# Rezoning Transportation Analysis

Petition Number: 2021-130

Date	Description
09-15-21	First Review (BKB)
10-18-21	Second Review (WB)
11-22-2021	Third Review (KP)

RZ1.0

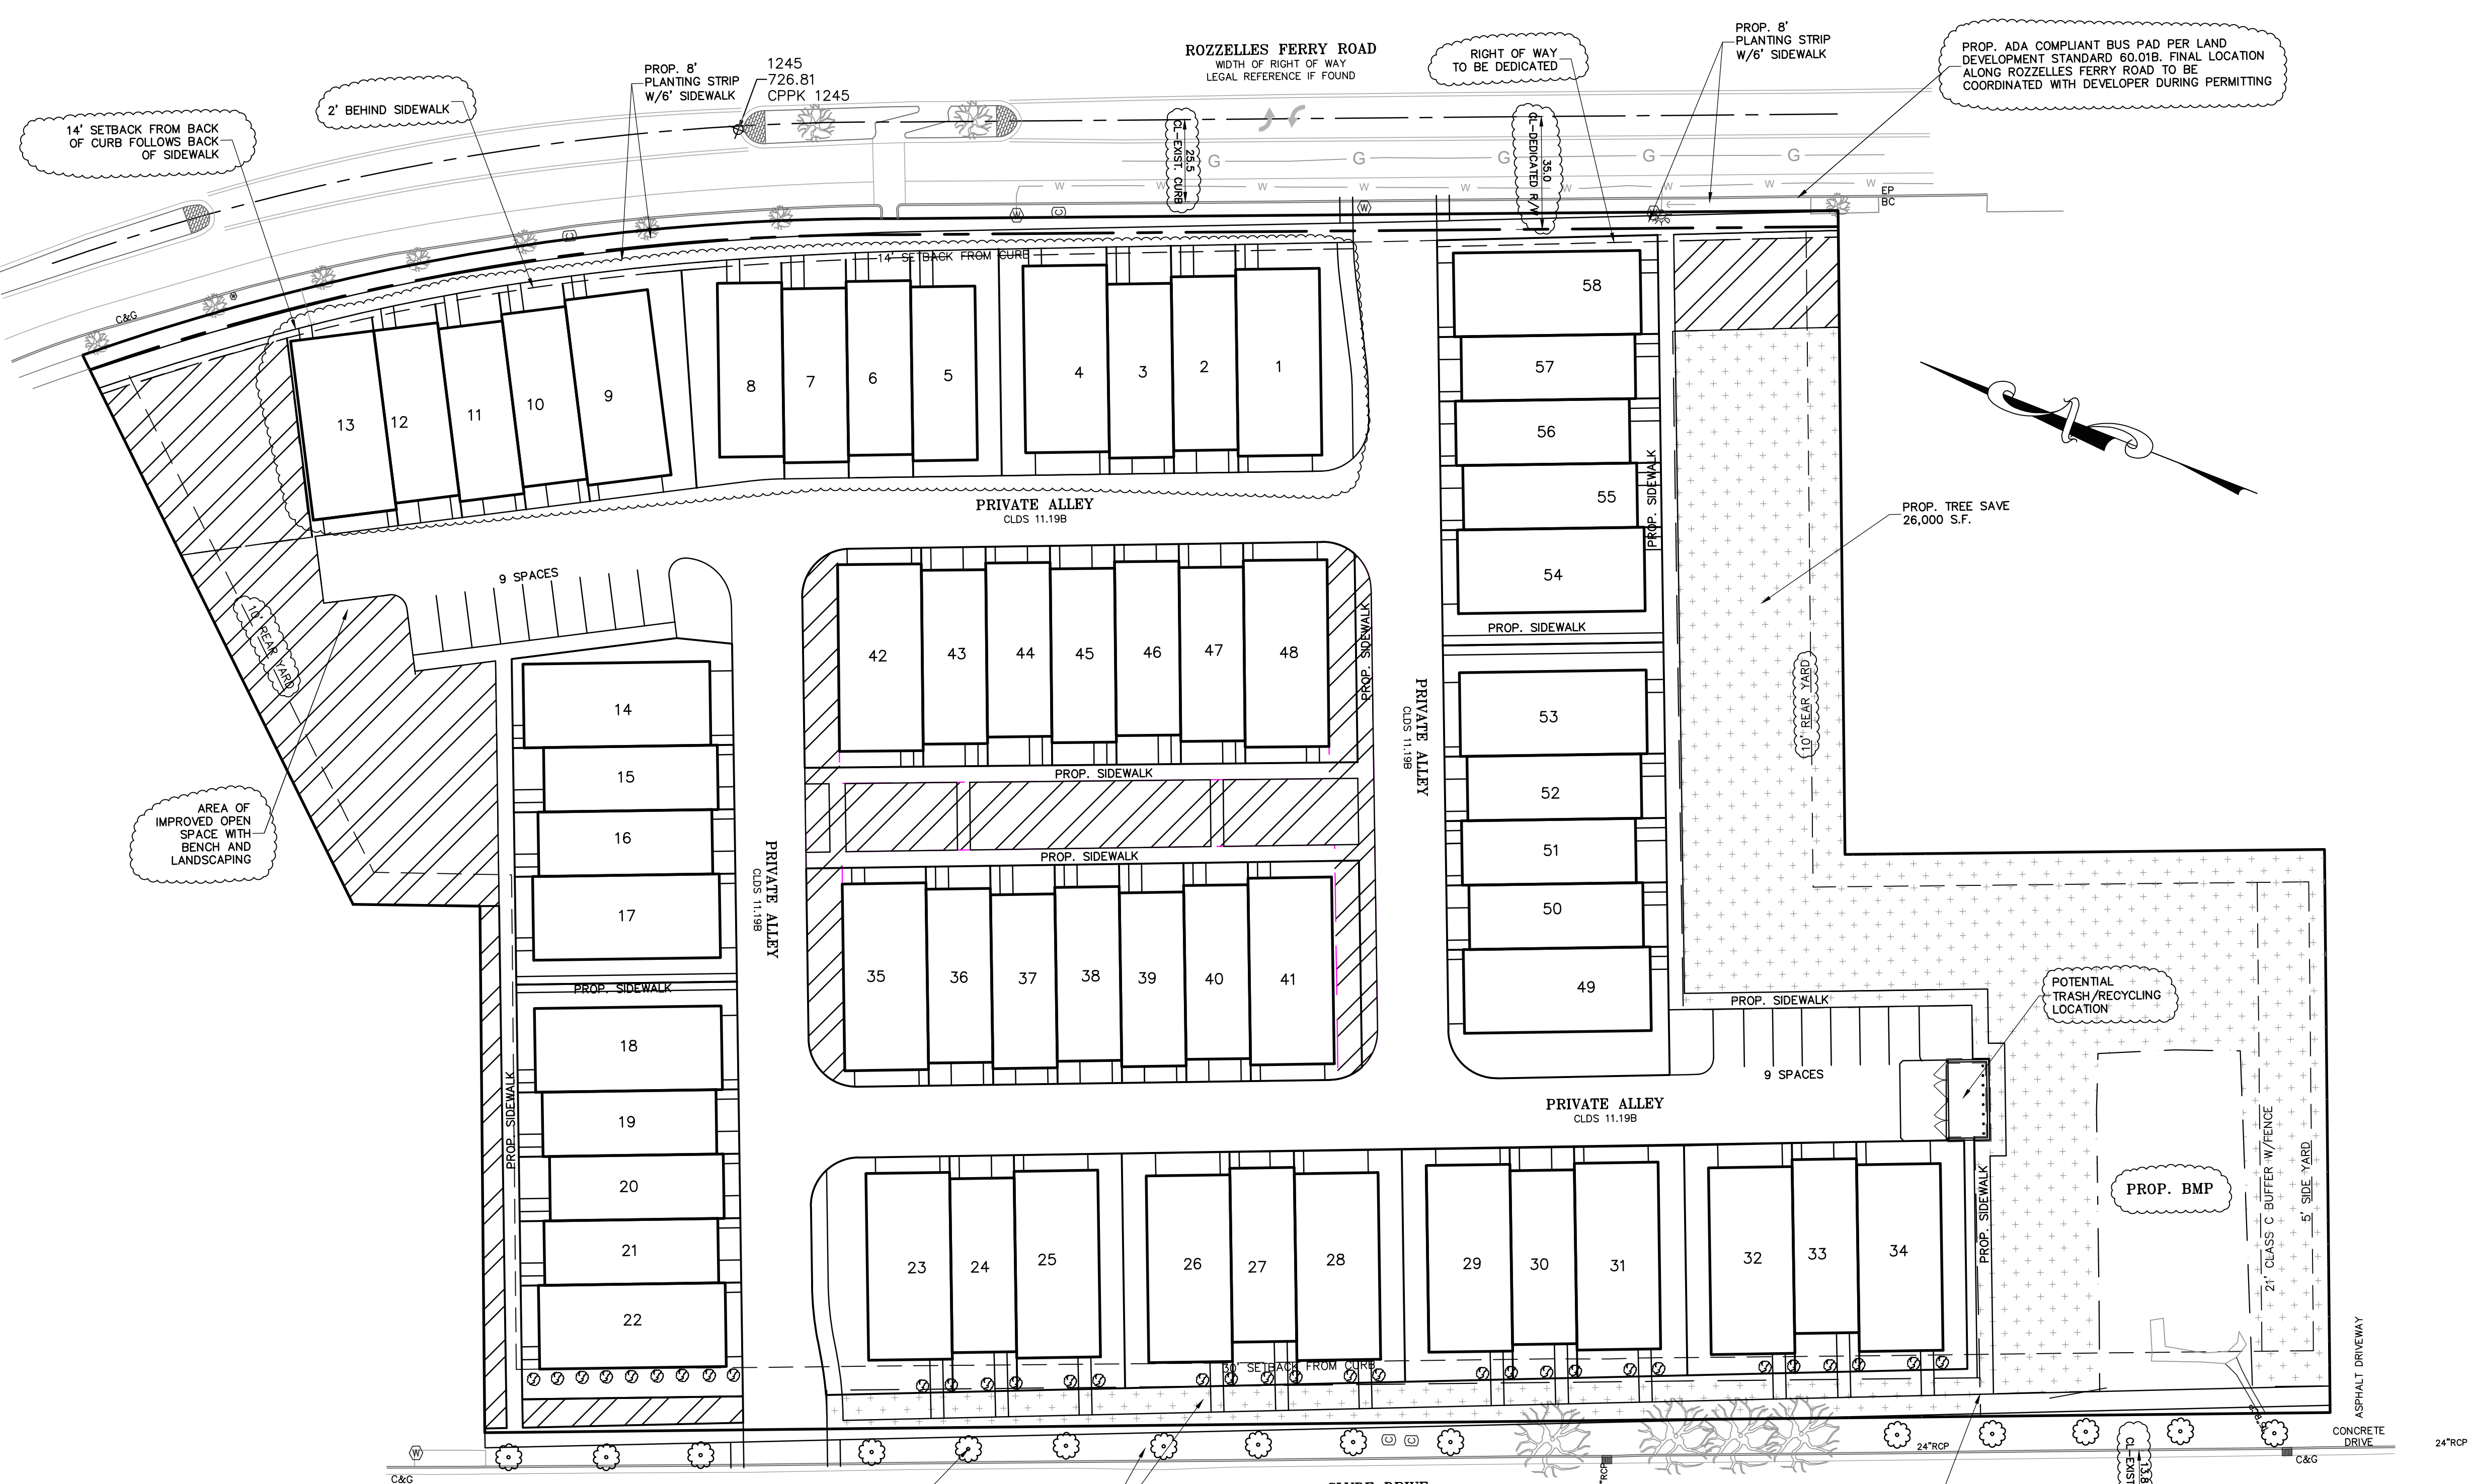
1. **Curblines:** ~~The proposed zoning district has a setback measured from back of the existing curblines.~~
  - a. ~~Label and dimension the curb and gutter from the centerline for each road on the site plan.~~

3. ~~Revise site plan and conditional note(s) to commit to dedicate 35 feet right of way from the road centerline on Rozzelles Ferry Road. The site plan shall label and dimension the right of way from the road centerline.~~  
**Comment Clarification (10/18/2021)** Future right of way to be labeled on the site plan as "Right of way to be dedicated".

4. ~~Revise site plan to include labels for all internal streets as "Private Alley" and reference CLDSM 11.19B.~~
